Application No: CM/43/21/DOC
Site Address: Bairds Farm Shop Crookthorn Lane Climping BN17 5SN
Description of works: Approval of details reserved by condition imposed under CM/16/21/PL relating to conditions 6-details of proposed grease trap/separator, 7-extraction details & 8-boundary treatments to southern & western boundary.

Thank you for your internet representation made on 16th August 2021 which has been recorded as an objection with the comments as follows:

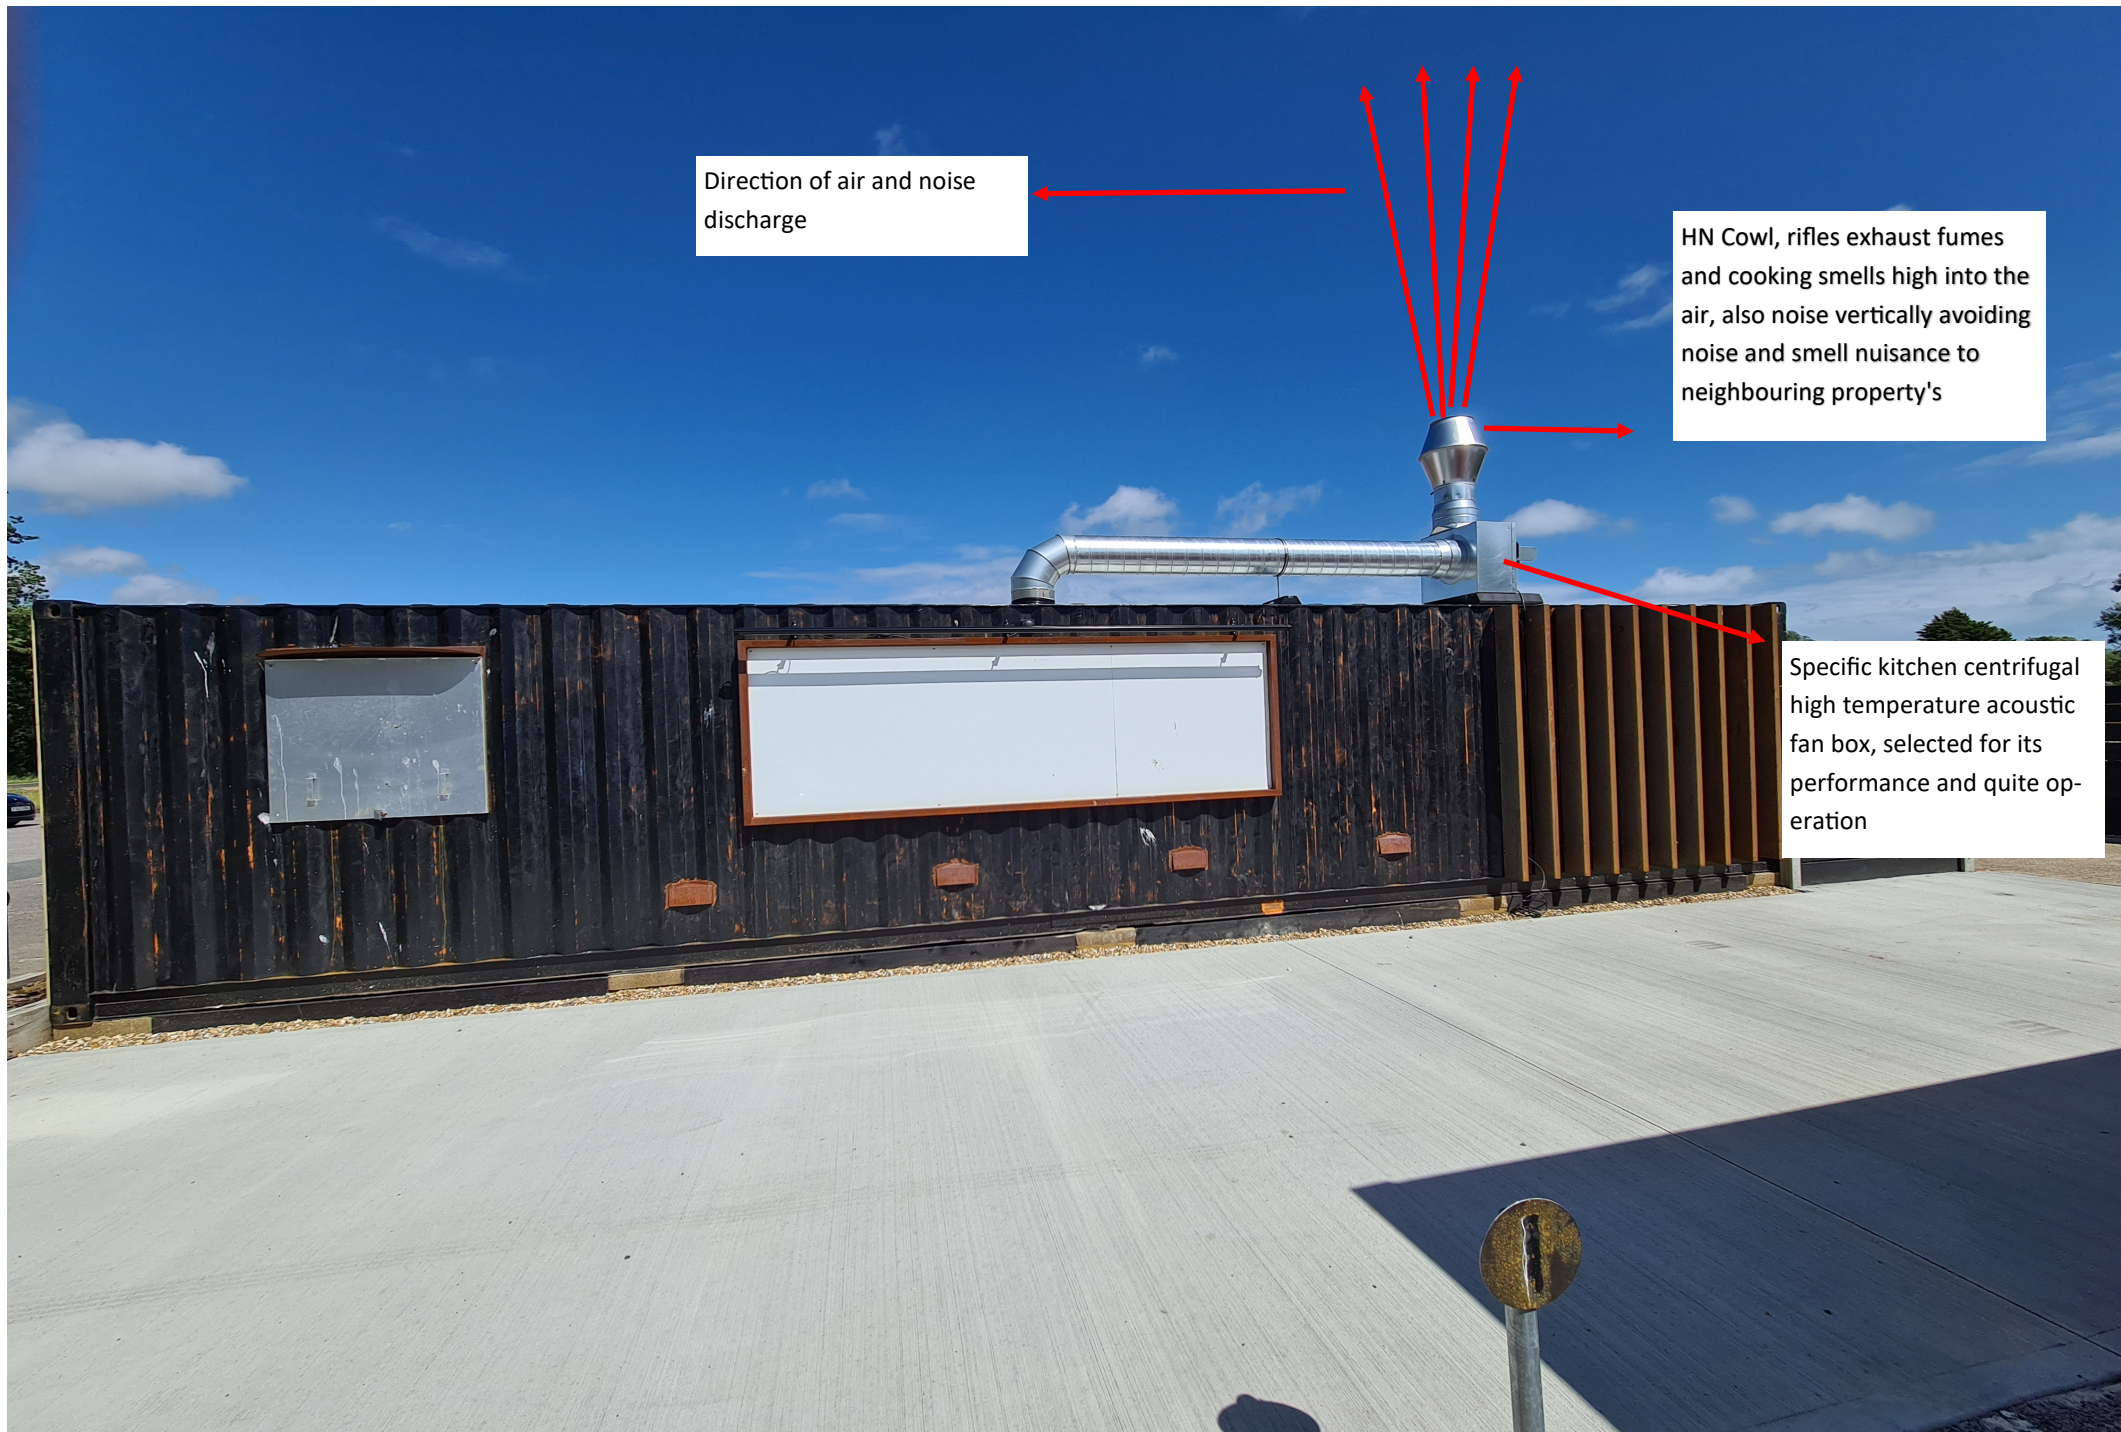
The proposed fencing simply will not screen the cottage effectively from the Drive through Caf . It is not an acceptable boundary treatment for the Grade II listed building. This is a serious concern now that we understand the height of the extraction system that was always planned but not shared with the Planning Committee. The height of the extraction unit will guarantee noise odour and disturbance reach the cottage.
